Lead Local Flood Authority
Post Point CHN 215
Hertfordshire County Council
County Hall, Pegs Lane
HERTFORD SG13 8DN

Date 01 October 2021

RE: 6/2021/2207/MAJ – Campus West, The Campus, Welwyn Garden City, AL8 6BX

APPENDIX E – EAS DRAWING 2486-SK04

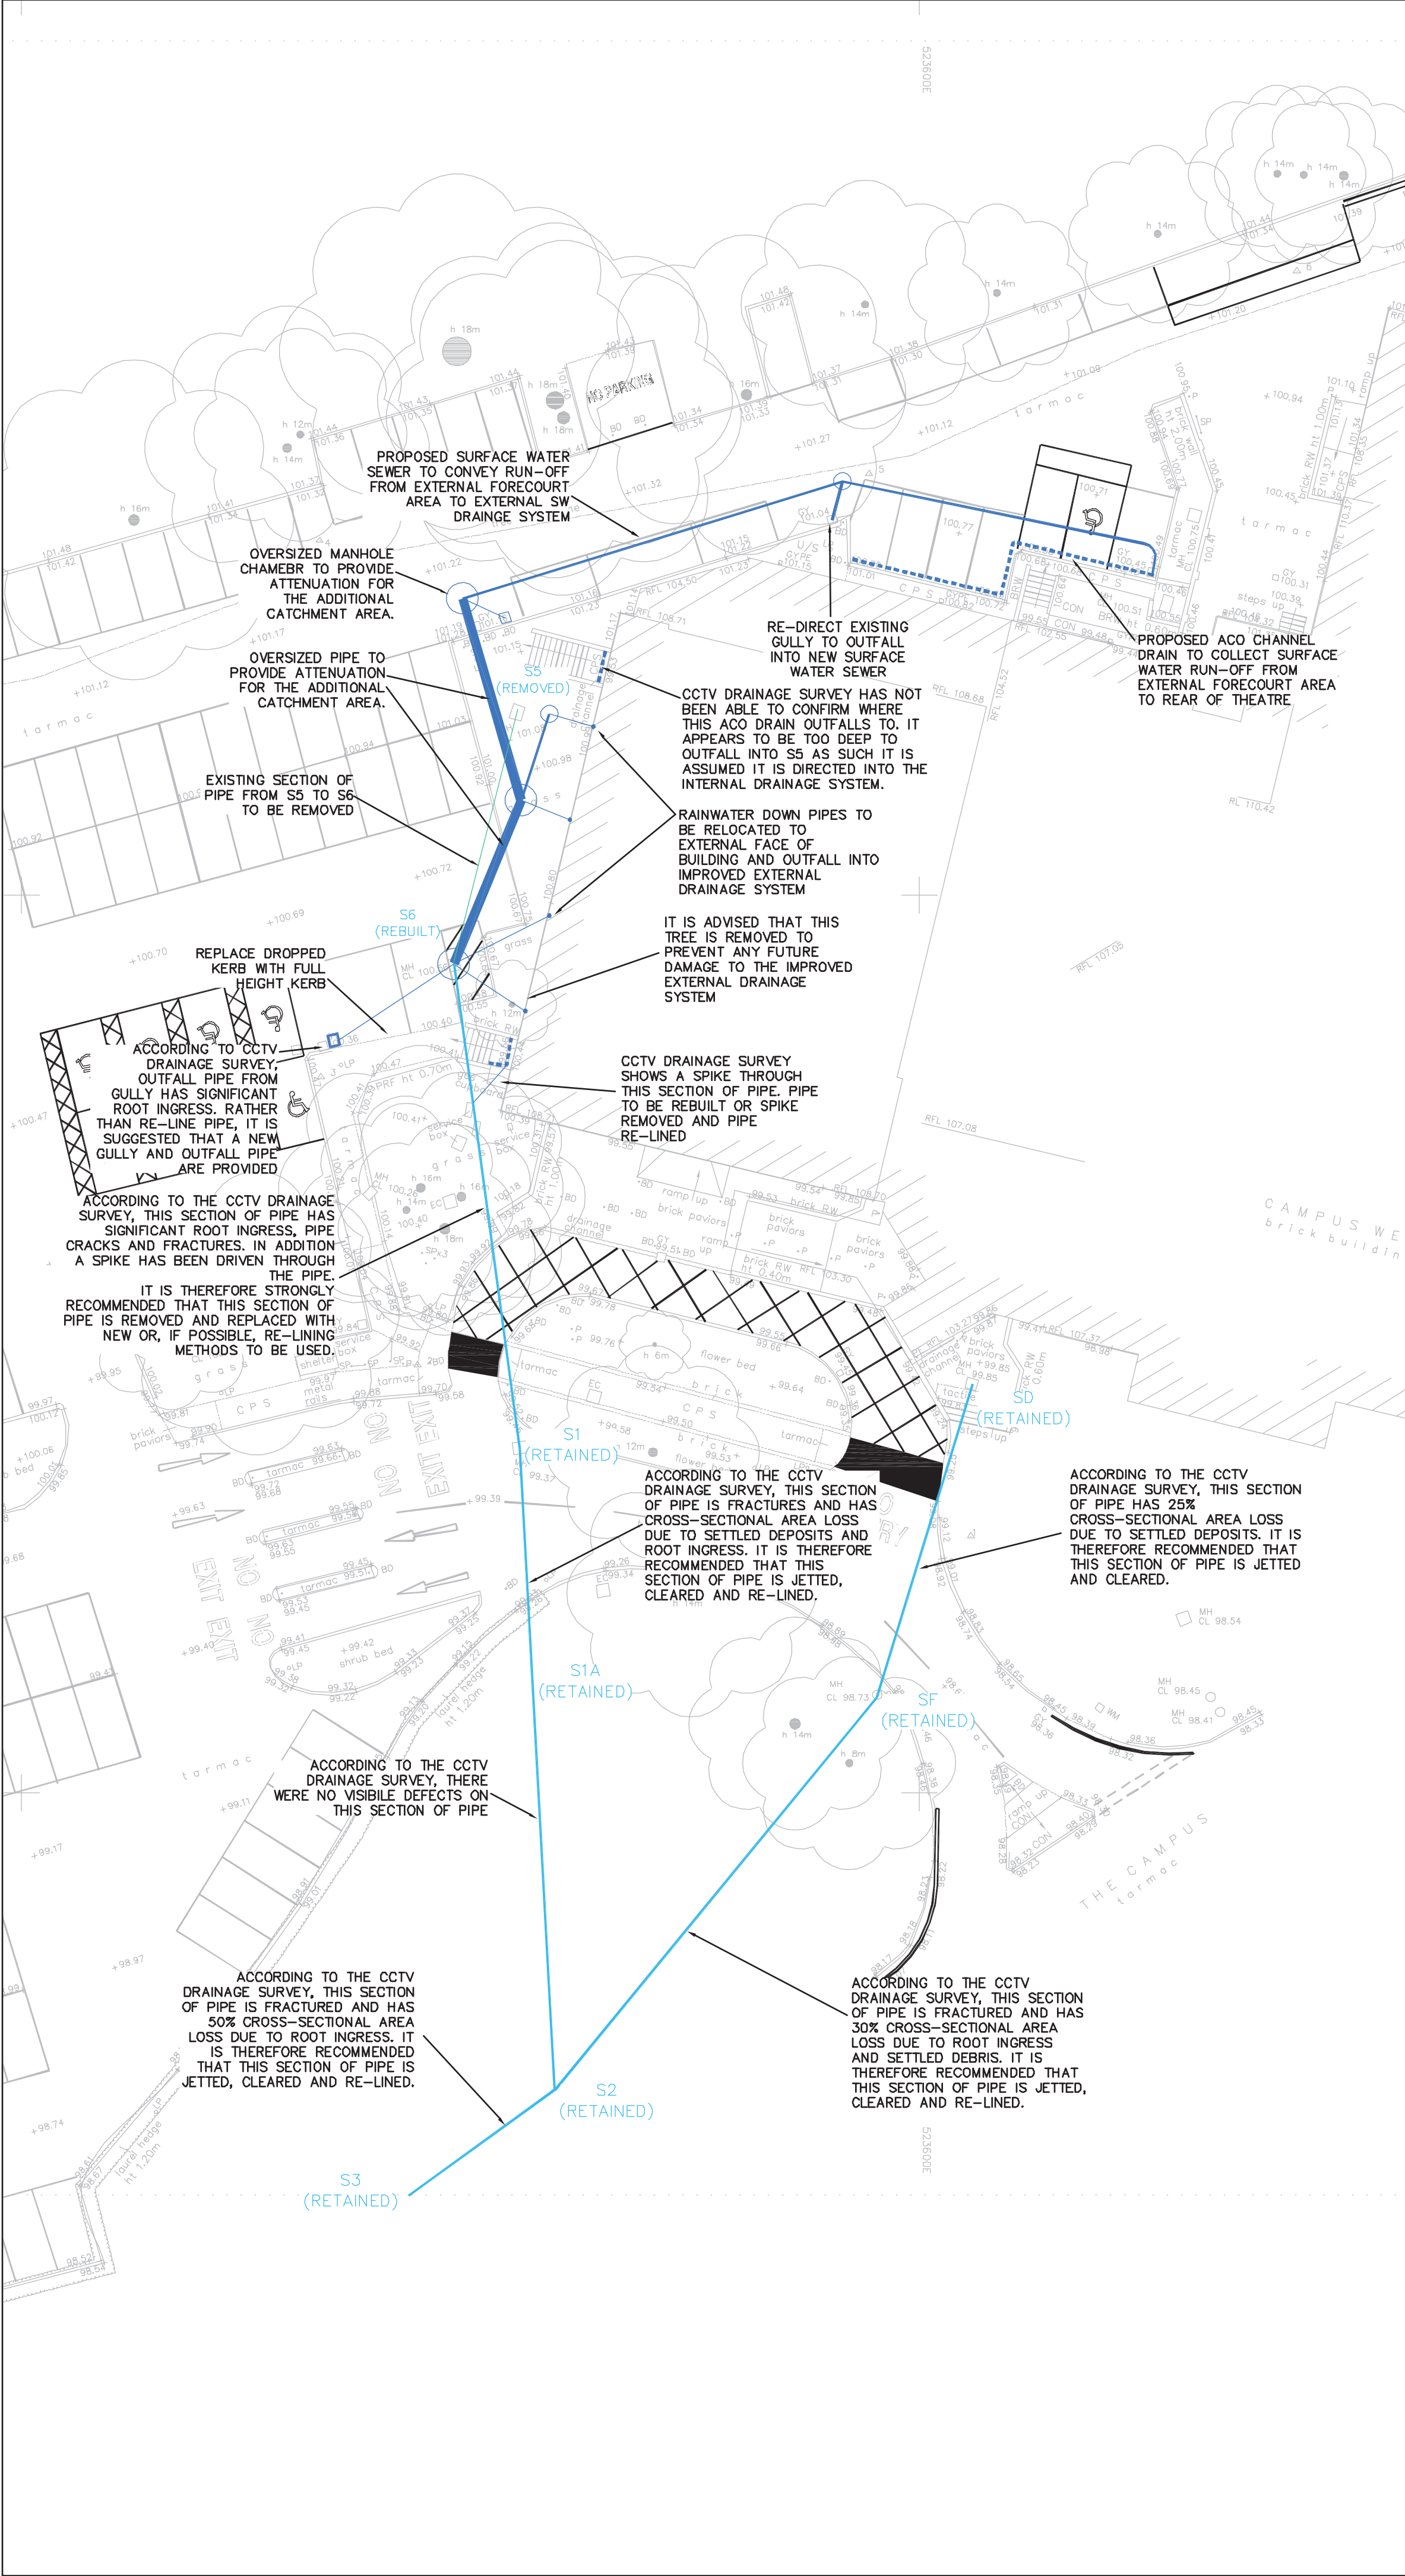
We note that the Drainage Strategy Plan makes reference to an EAS Drawing 2486-SK04 for Details of Proposed Roller City Drainage Improvements Works. If part of the site is to be drained via a separate drainage system, the drawings should be submitted to the LPA.

If there are areas of the site that are proposed to be drained via a separate drainage system, the plans should be submitted to the LPA.

APPENDIX F – DRAINAGE STRATEGY

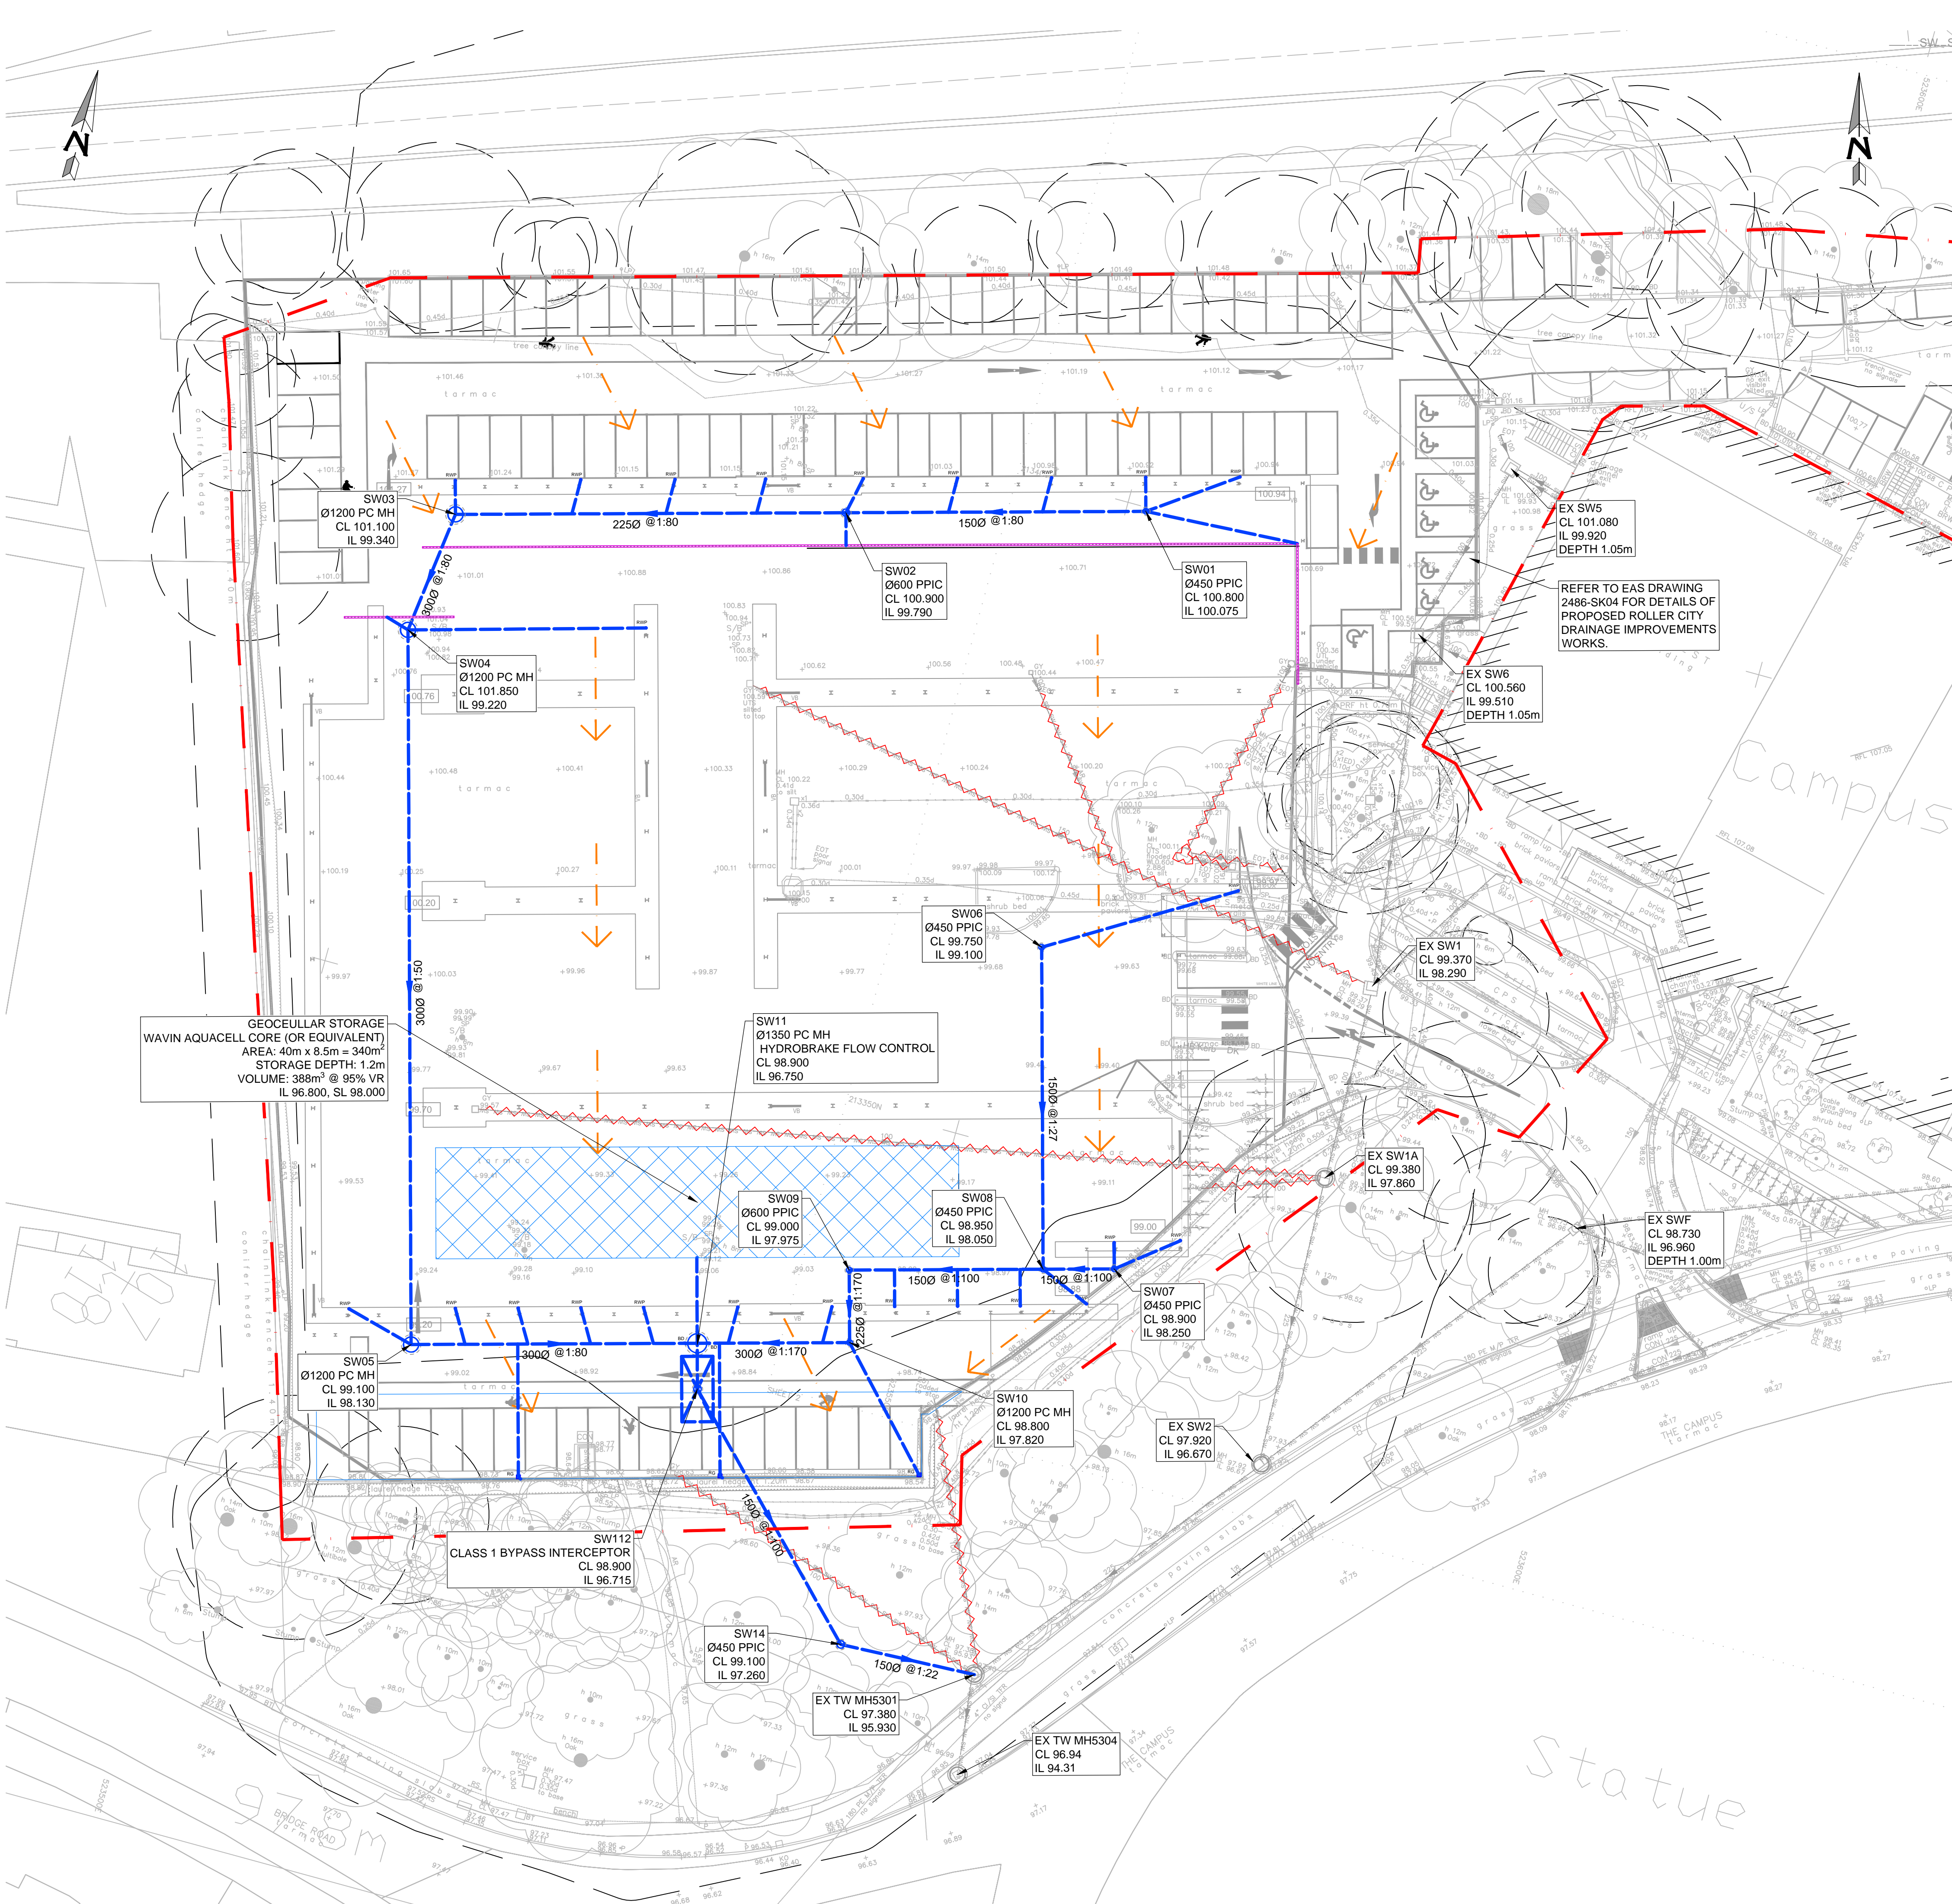
We understand that the site plan has been updated since the Pre-Application stage where the LLFA were consulted. We note there is additional area included in the site layout now and the drainage strategy has not been updated to include the additional area.

We understand that the surface water scheme for the site proposes to discharge into the existing Thames Water surface water sewer located to the south of the site. It is understood that the surface water discharge will be restricted to 5l/s.

It is noted that a geo-cellular storage structure is to be located underneath the car park footprint to provide surface water attenuation for all events up to and including the 1 in 100-year return period including an allowance for climate change.

We would expect the applicant to provide confirmation from Thames Water that the proposed connection and discharge rate is acceptable. A Pre-Planning enquiry confirmation should be sought from Thames Water.

The applicant should update the drainage strategy to include the additional site area as we would expect the applicant to actively drain the entire site area. If there is existing site drainage that is to be reused for the additional site area this should be submitted to the LPA.
